Our Ref: EG/6/18/RES
Your Ref:

Application for Approval of Reserved Matters Following Outline Approval

Development Approval of reserved matters following outline consent EG/71/14/OUT for the erection of 60 No. dwellings with new vehicular access, open space & ancillary works. This application is a Departure from the Development Plan.

Location Eastergate Fruit Farm Barnham Road Eastergate

17-1103-037

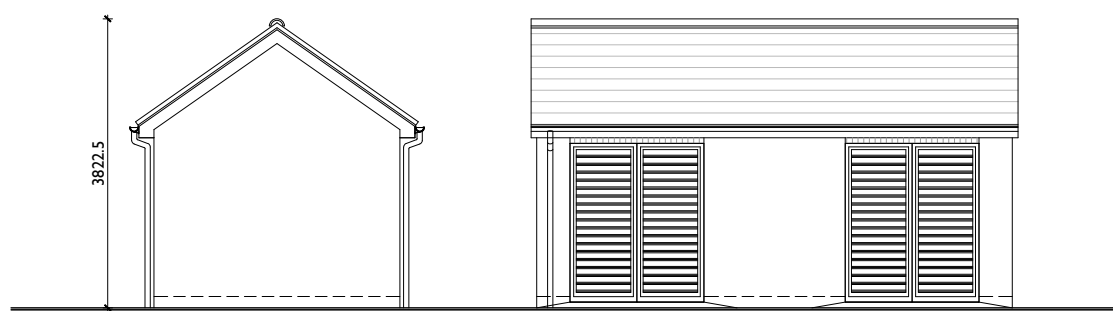
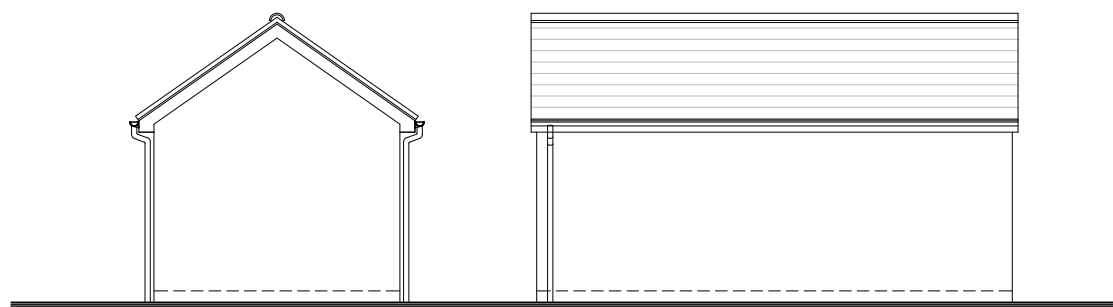
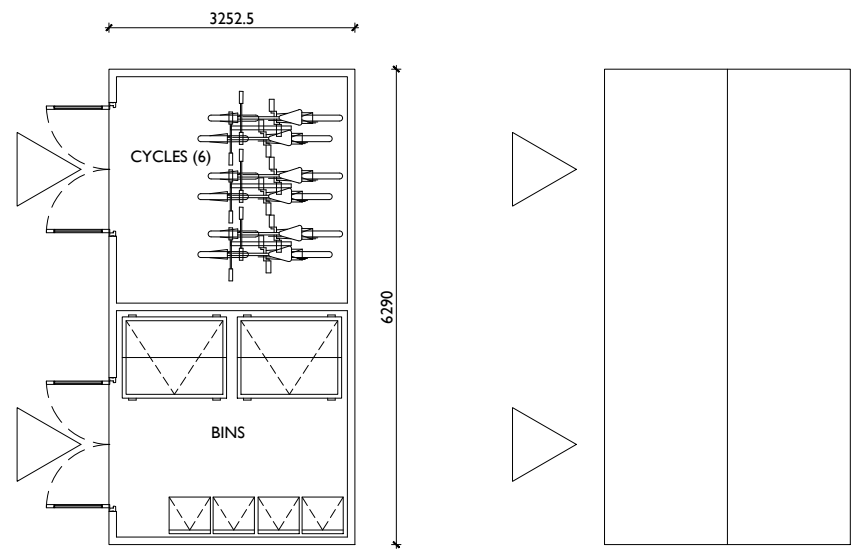
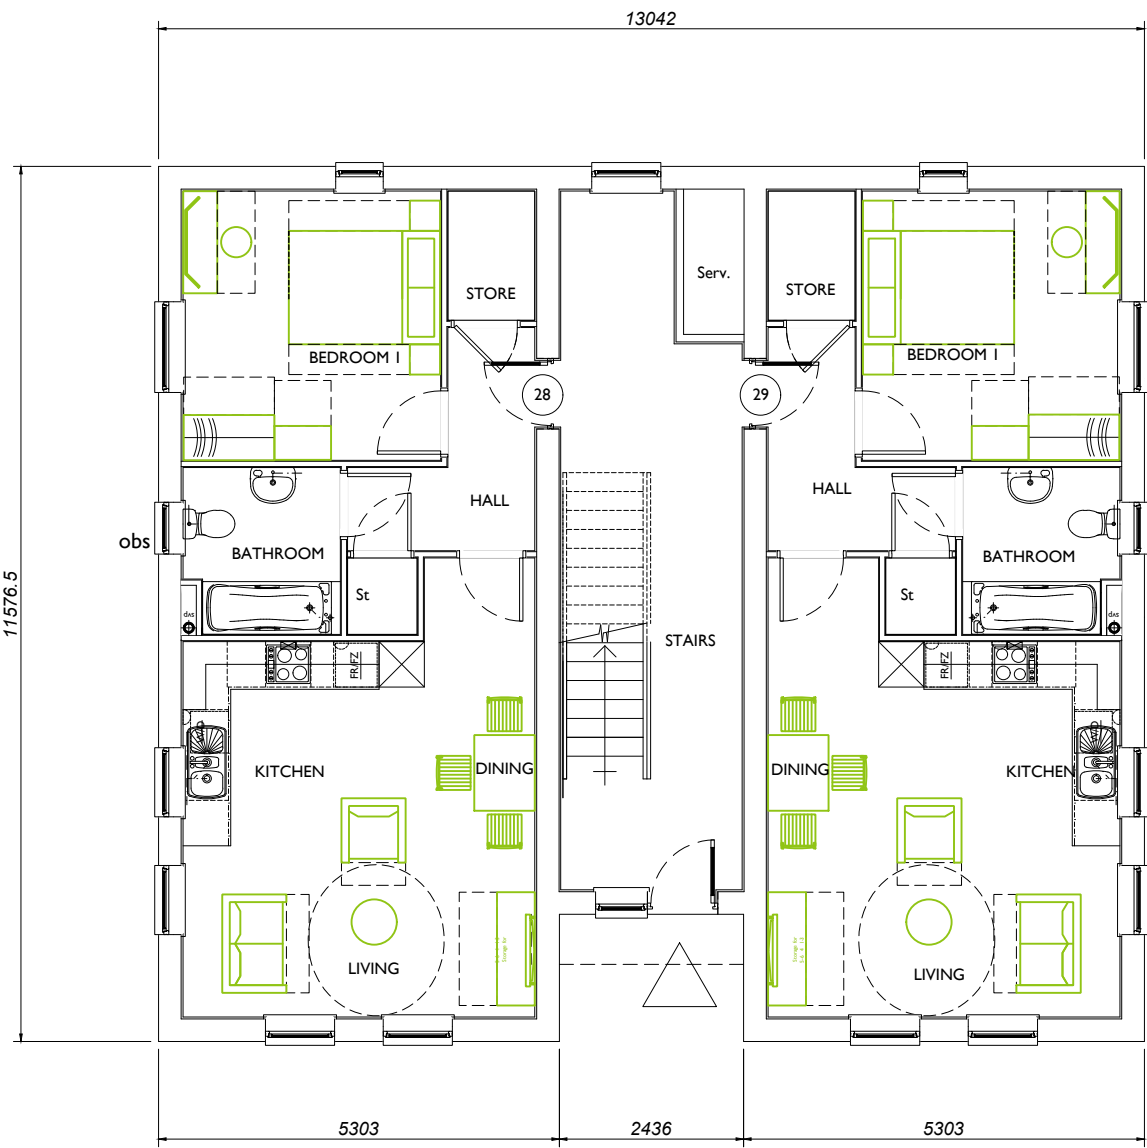
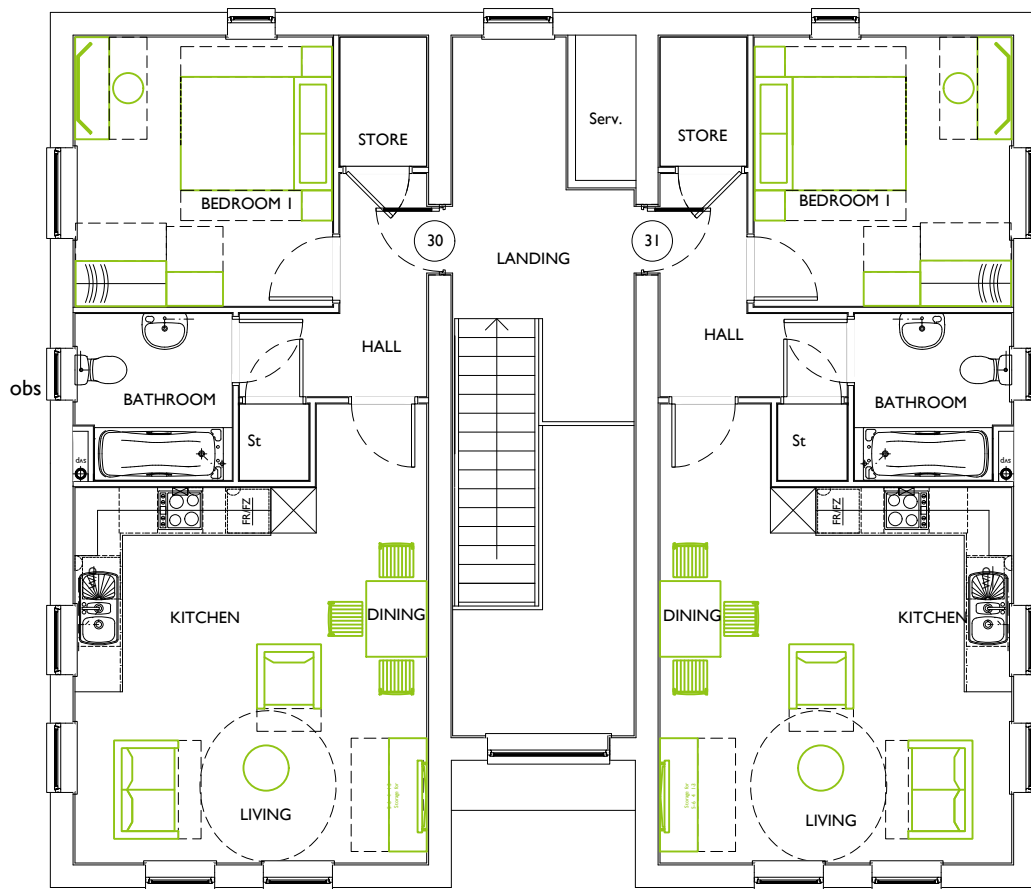
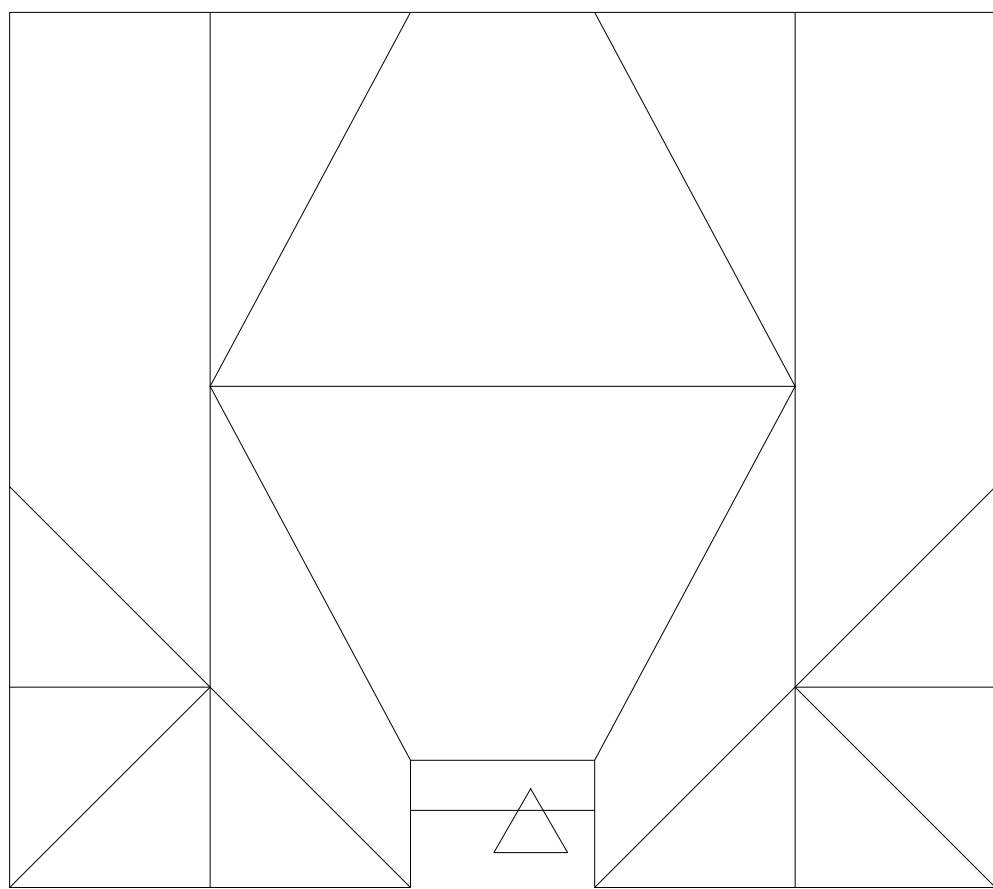
For Plots 32-34 House Type A2, plan number 17-1103-038, the rear elevation is labelled as 39, 40 & 41 while the title of the plan is annotated as plots 32, 33 and 34.
